Online Comment

Application H22-0684-23
Location 28 Broadgate Weston Hills Spalding PE12 6DG
Proposal Demolition and replacement of existing dwelling including change of use of agricultural land to residential curtilage - re-submission of H22-0058-23

Name Jim Bonnor
Address Historic Places Team Lincolnshire County Council

Date Submitted 31-08-23
For/Against Comments

SITE PLAN 1:500

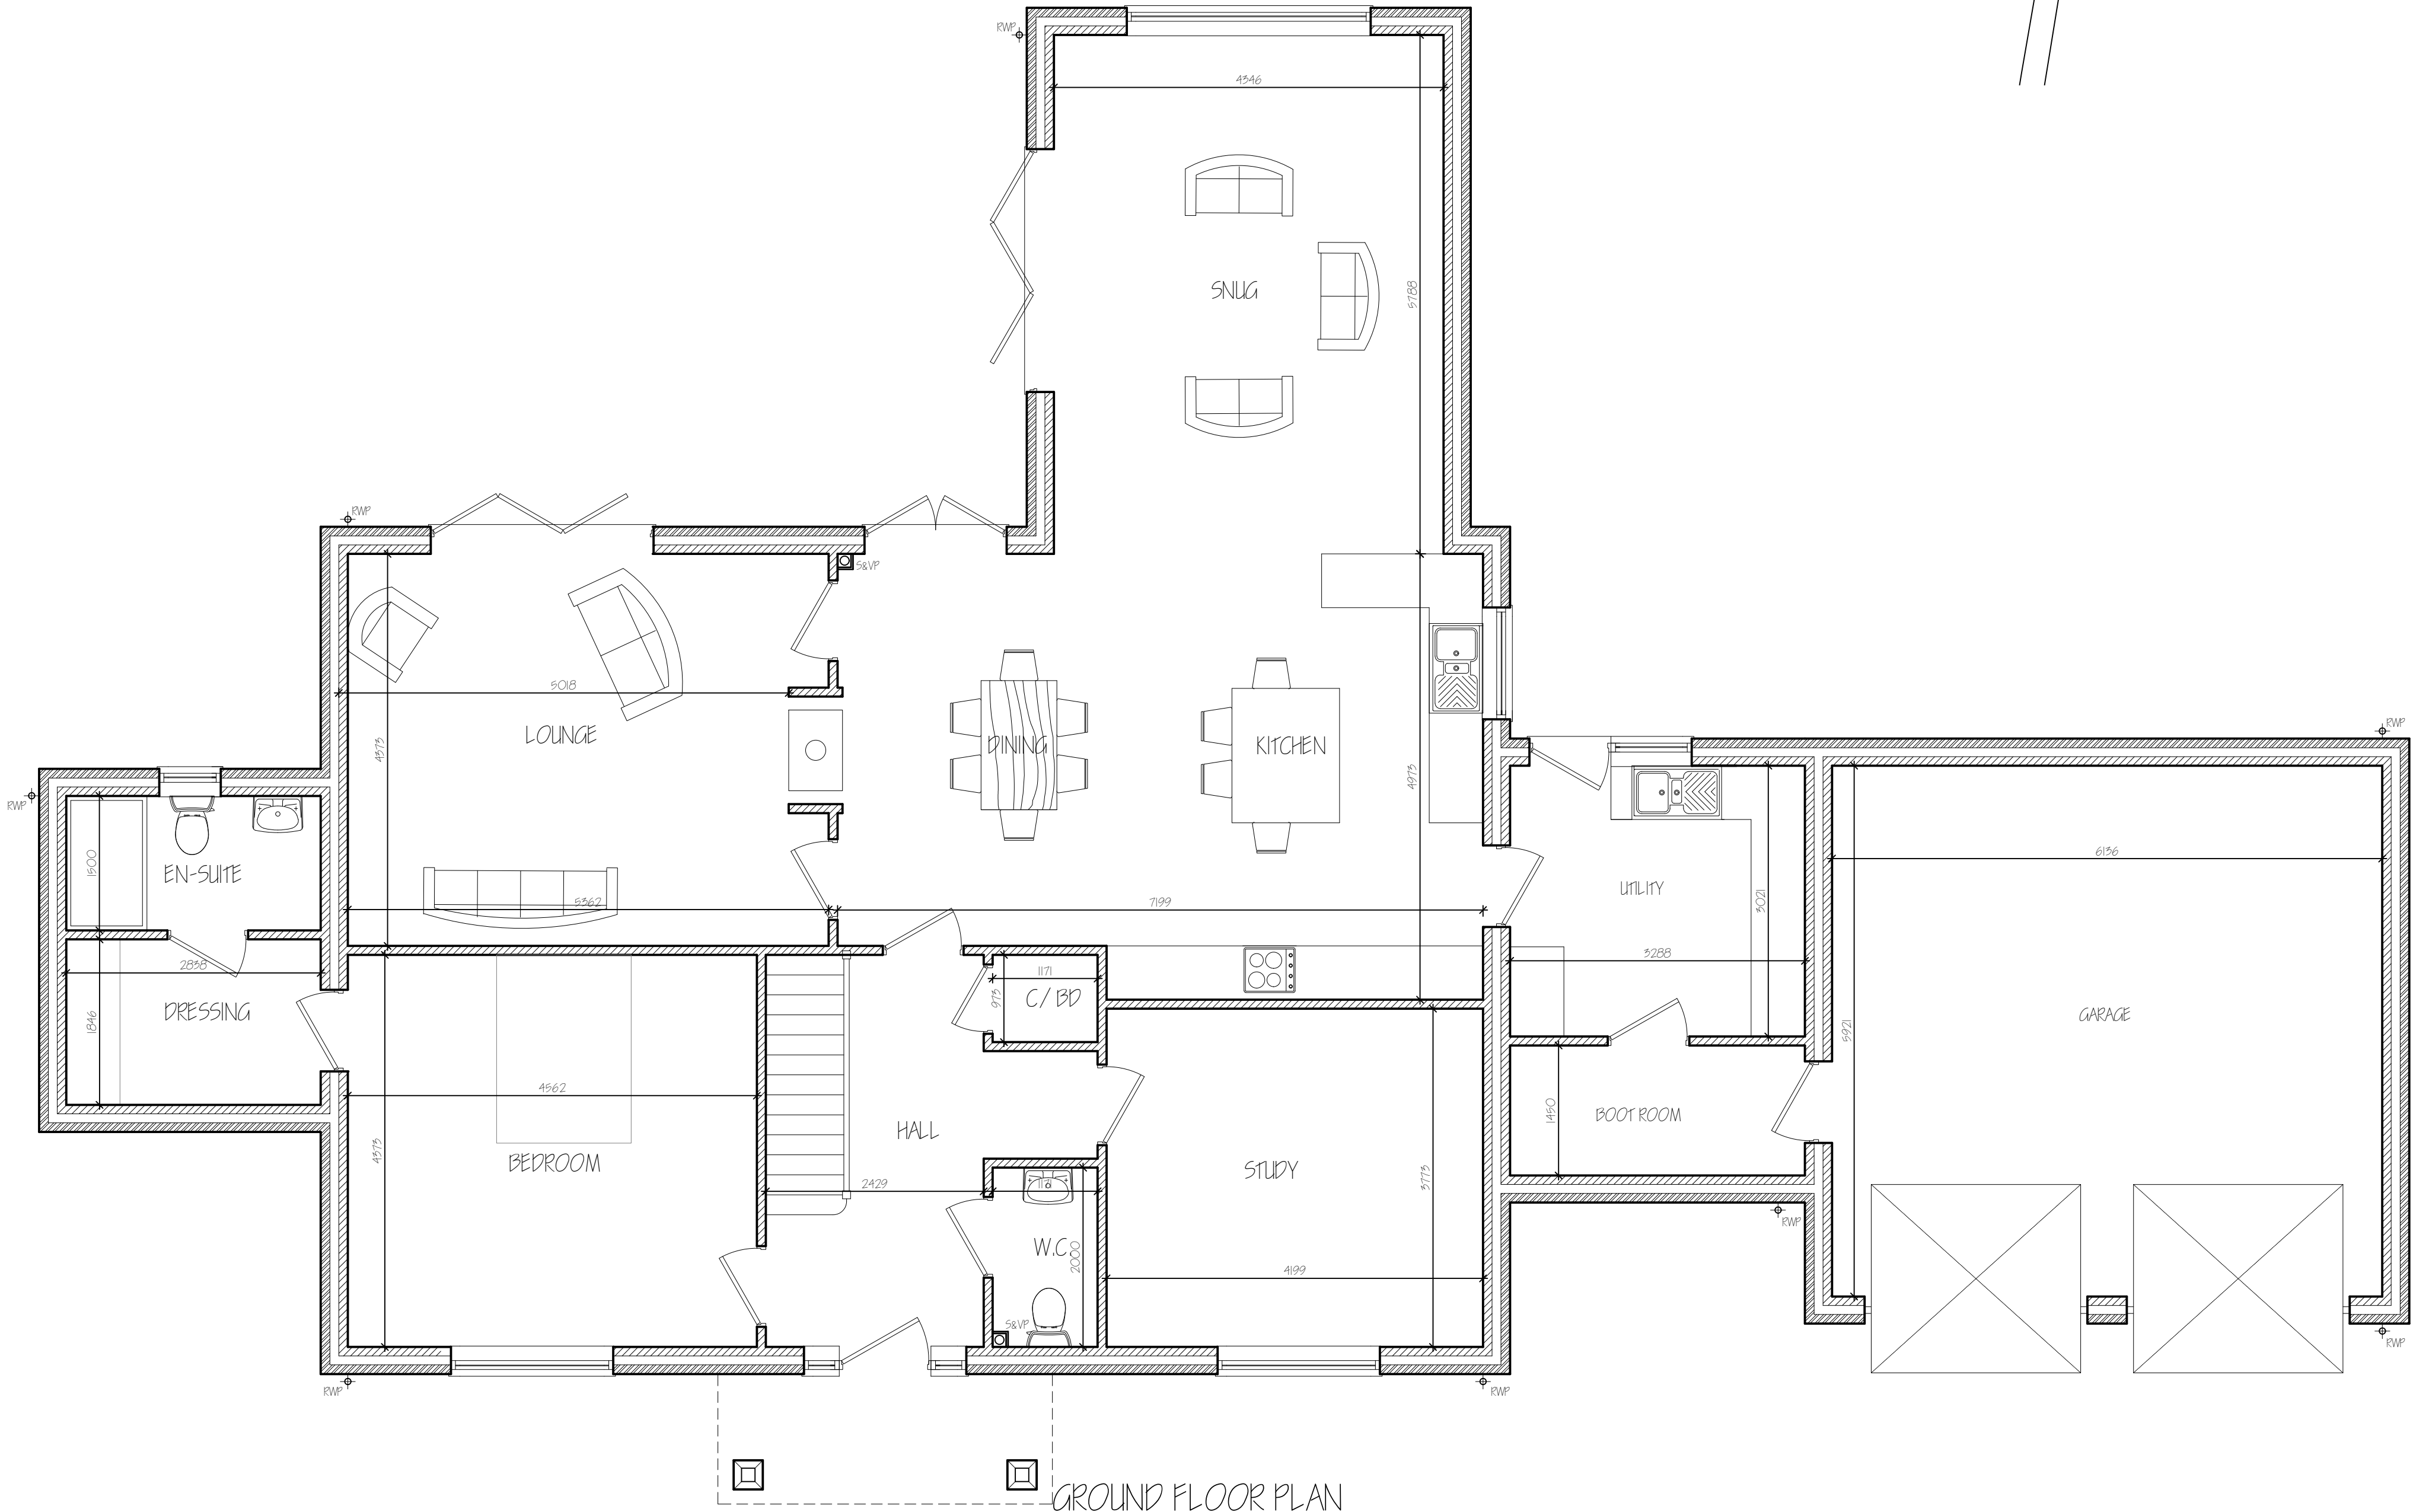
Reason: to ensure an appropriate record of the building has been made prior to demolition. I also note that the proposed new dwelling is larger than that previously proposed and will occupy a new footprint to the east of the current dwelling, extending into the field to the north which is to be part of the garden of the new property. Within the field on the opposite side of the road an extensive area of ring ditches has been identified from aerial photographs, along with several other linear features which may be trackways. While the ring ditches may be Bronze Age in date and represent the remains of prehistoric burial mounds, it is considered more likely that these represent dwellings, round house, and are later prehistoric and/or Roman in date. Further cropmarks of Roman period settlement are known to the northwest of the site.

This indicates that the site is within an area of considerable archaeological sensitivity and the proposed development has the potential to damage or destroy significant archaeological remains.

While I appreciate that this matter was not raised for the previous application, it would be consistent with our advice for other similar development in the vicinity to recommend that the developer should be required to commission a Scheme of Archaeological Works (on the lines of 4.8.1 in the Lincolnshire Archaeological Handbook). This should be secured by South Holland District Council's standard conditions AR01, 02 and 03.

Initially I envisage that this would involve monitoring of all groundwork's, with the ability to stop and fully record archaeological features.
